From: Amanda Scholes on behalf of Planning.Responses
Sent: 10 November 2020 08:18
To: Planning Scanning
Subject: FW: Planning Consultation on: AL/64/20/PL

Response to Planning Application

Application ref: AL/64/20/PL

Description: Demolition of the existing dwelling & construction of 2 no. 2-bed. 3 no. 3-bed, 4 no. 4-bed houses including access, landscaping & associated works (resubmission following AL/27/20/PL).

Tree Retention and Protection Plan

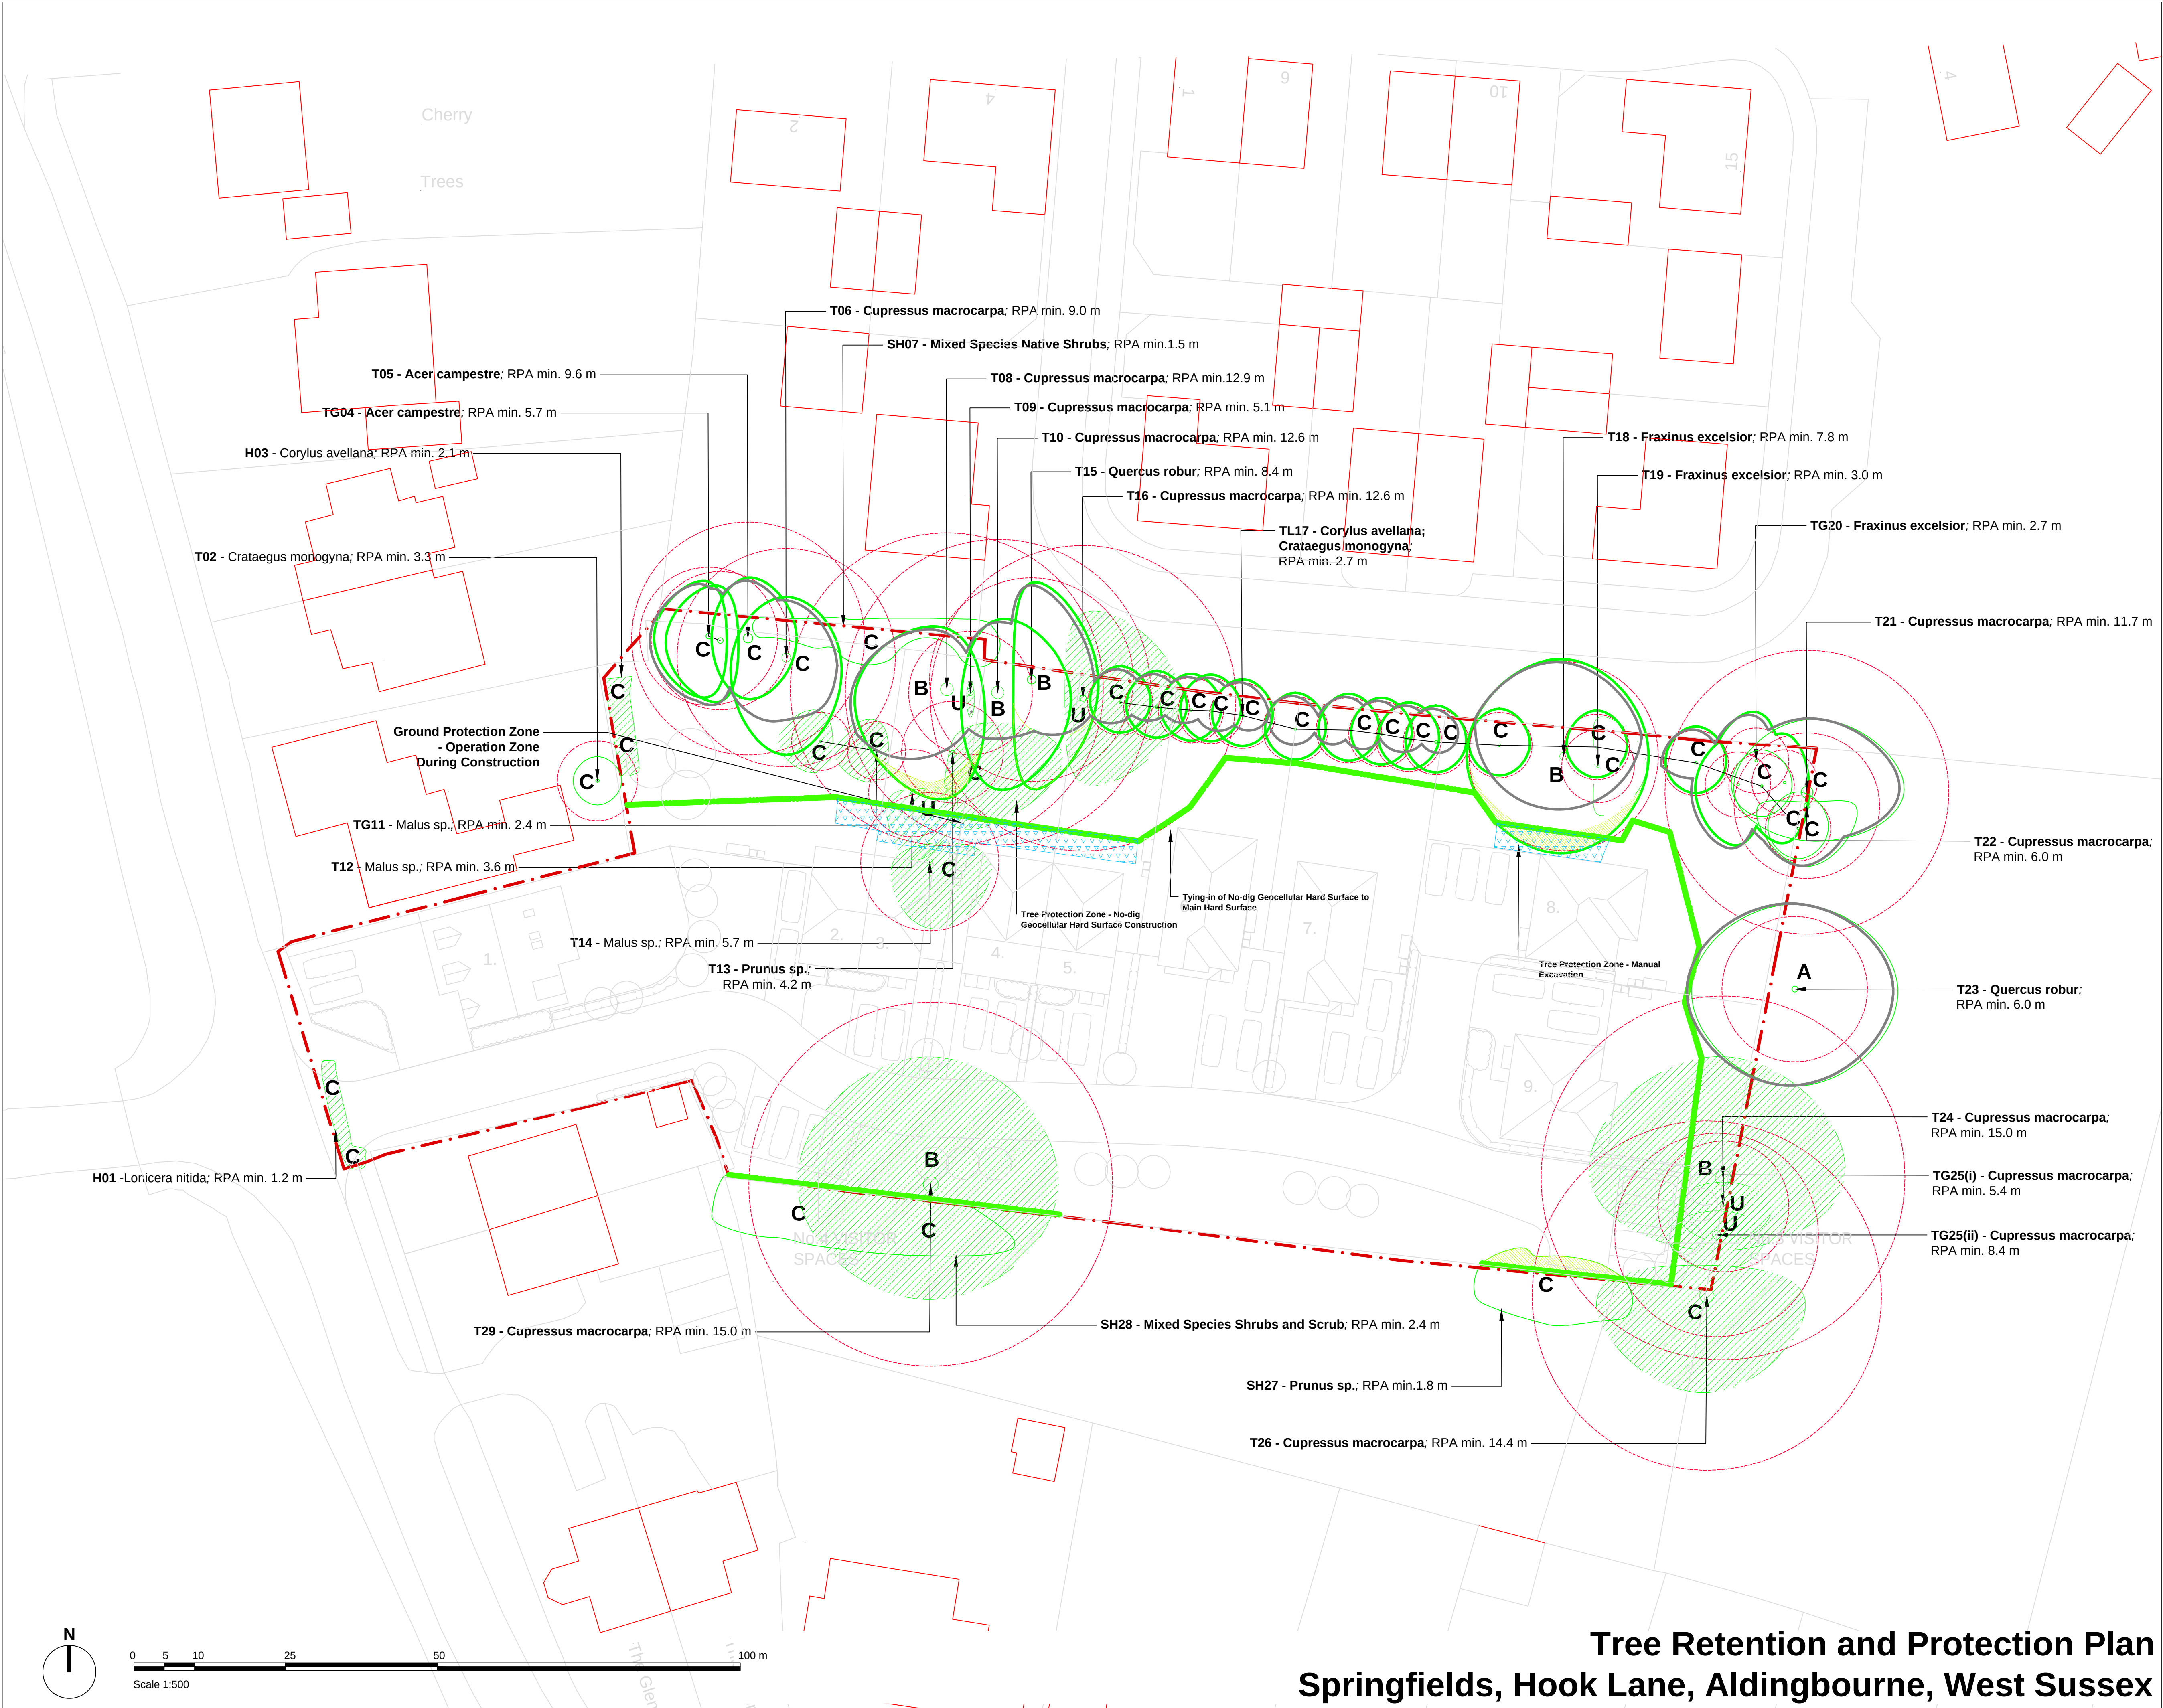
Any adjacent trees associated with this location and offsite that may have roots within the development area should be subject to tree protection measures. There may be conflict with existing trees to the north of this proposed development. Any tree removal/protection must be in agreement with Arun District Councils Tree Officer.
